10 June 2021

TfNSW Reference: SYD16/01747/07

Client Reference: SSD 7709 MOD 2

**MODIFICATION TO CONSTRUCTION RELATED CONDITIONS, MOOREBANK
PRECINCT WEST STAGE 2 - MOOREBANK AVENUE AND ANZAC ROAD
INTERSECTION UPGRADE, MOOREBANK**

**POST APPROVALS - MPW
MASTERPLAN - PART 1**

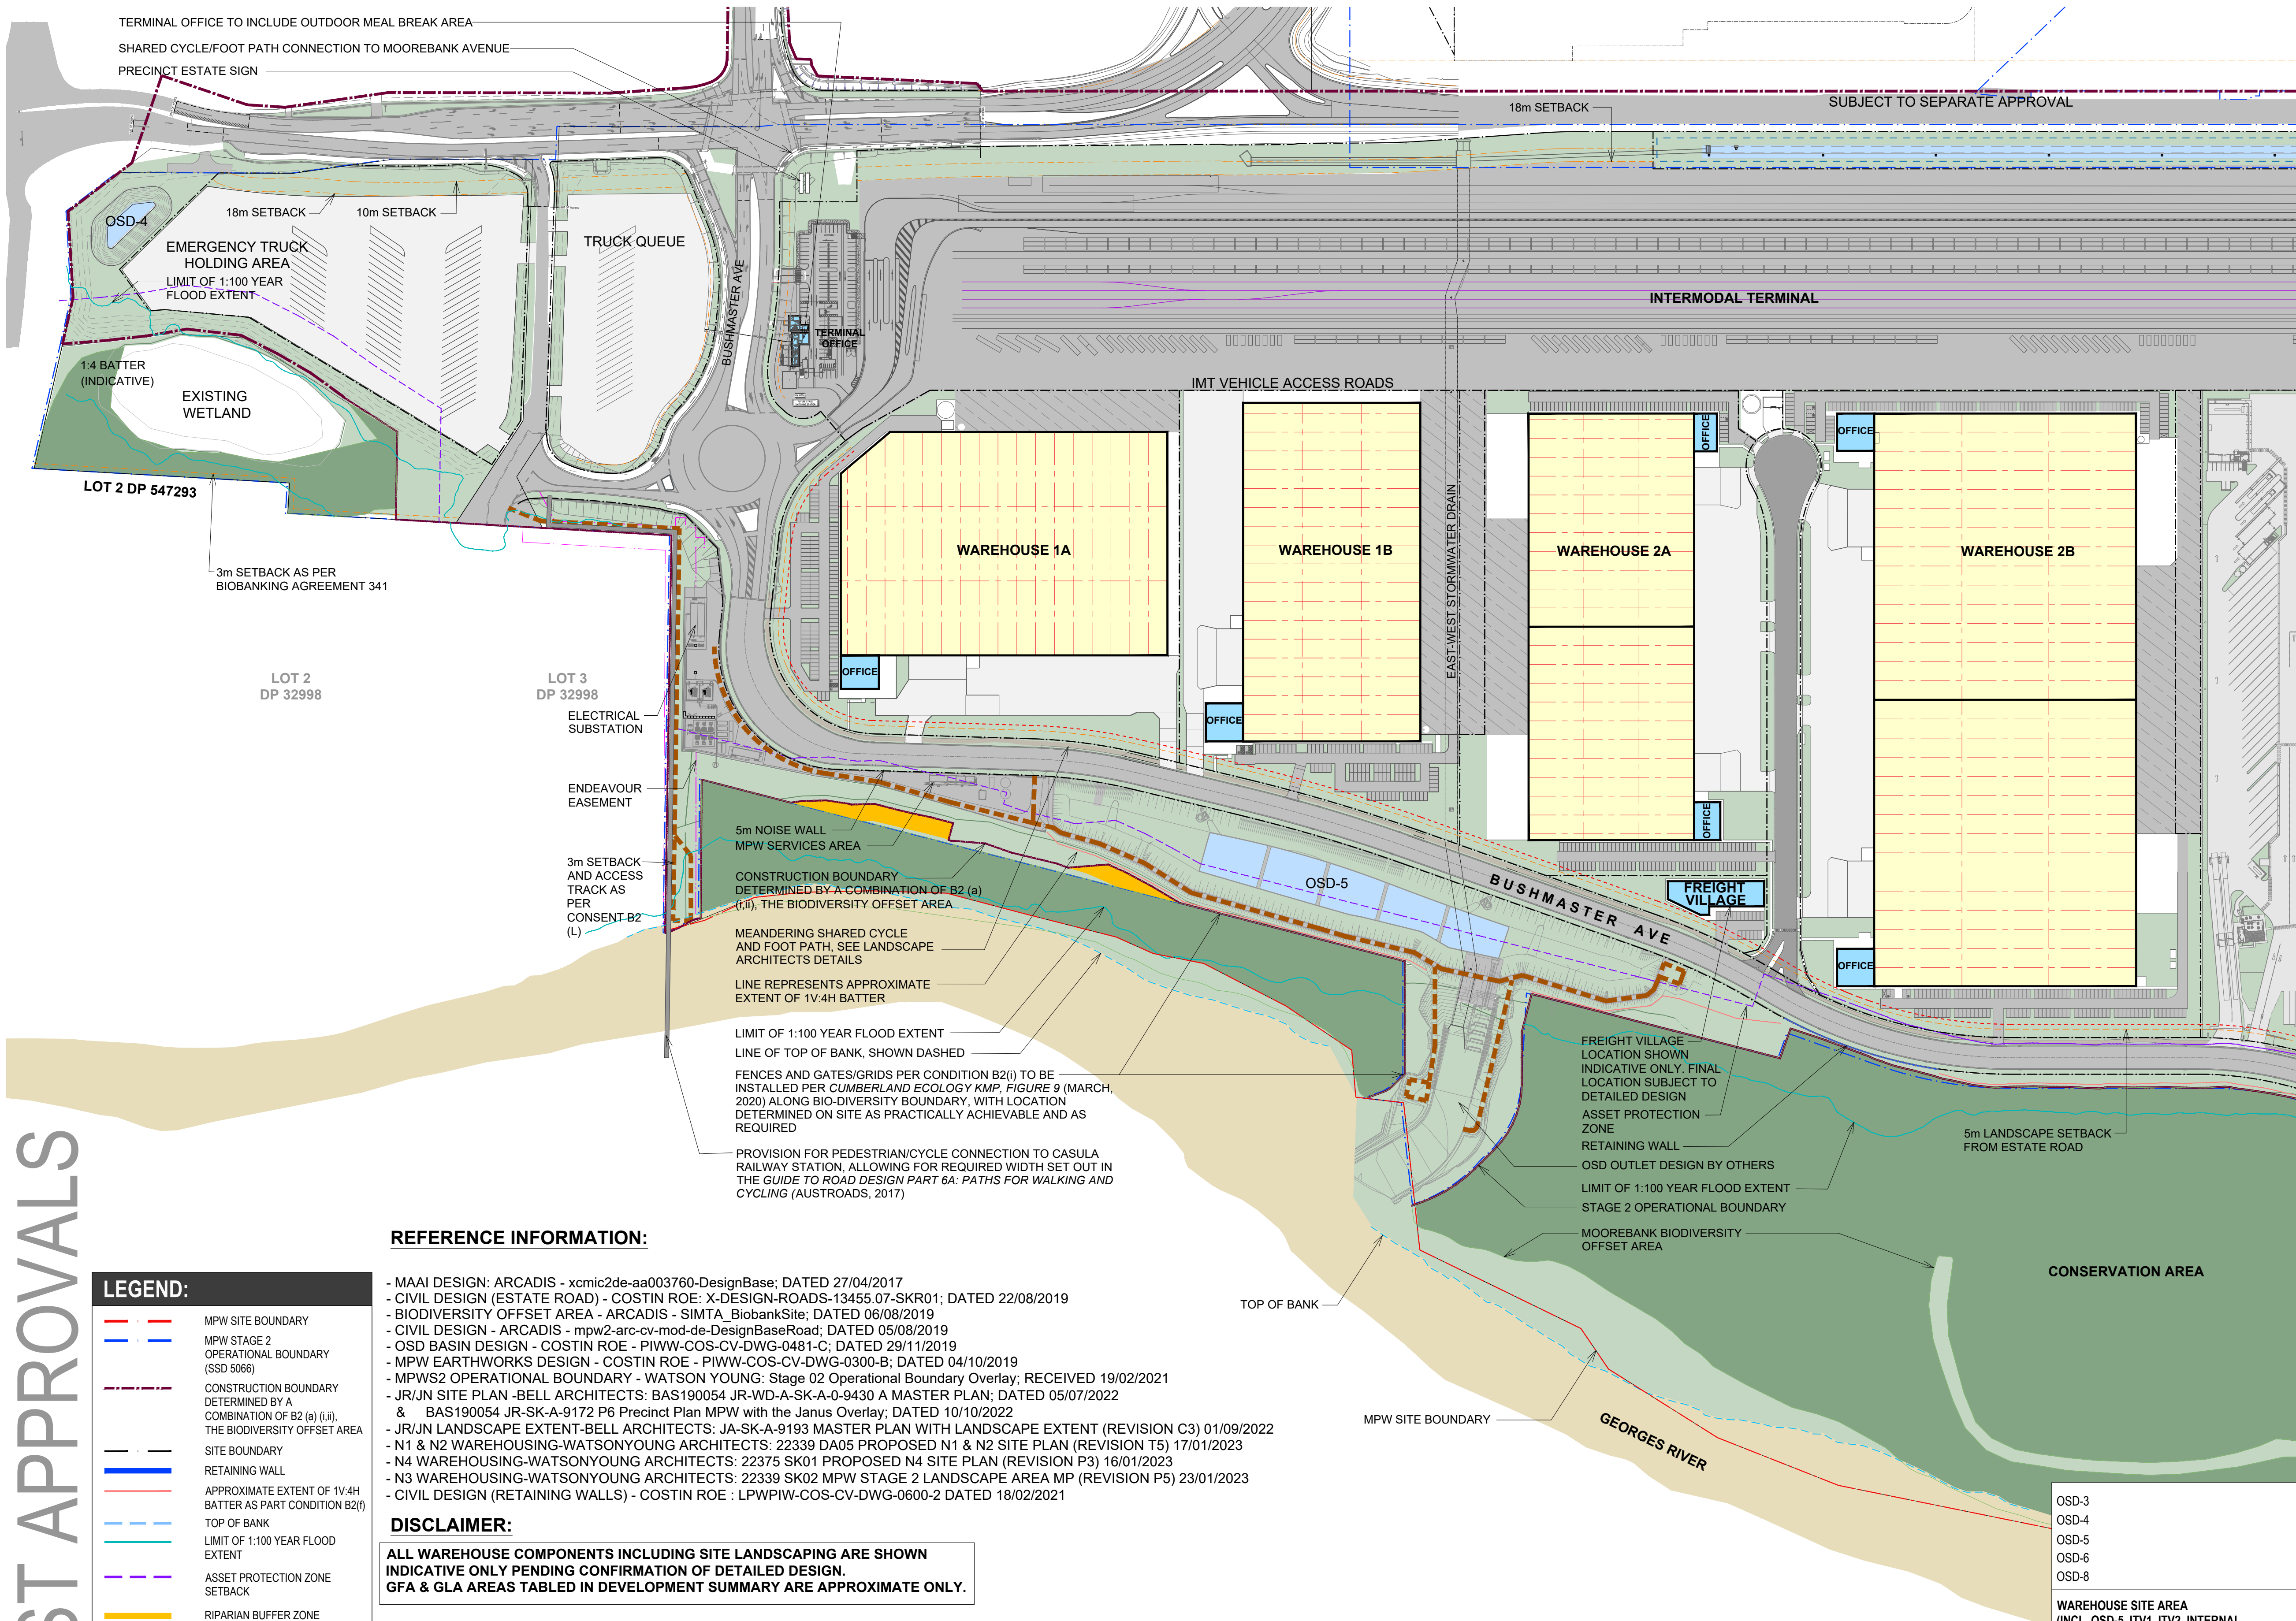
4. The Department of Planning, Industry and Environment needs to be satisfied that the proposed relocation of an existing overhead 33KV (high voltage) transmission line on Anzac Road is permissible under section 4.55 of the EP&A Act.
5. TfNSW notes that the plan provided in Appendix B - Updated MPW Masterplan entitled "*Access Masterplan*" dated April 2021 of the proposed modification application does not appear to form part of this application, nor has it been assessed and is therefore irrelevant, and as such should be disregarded.
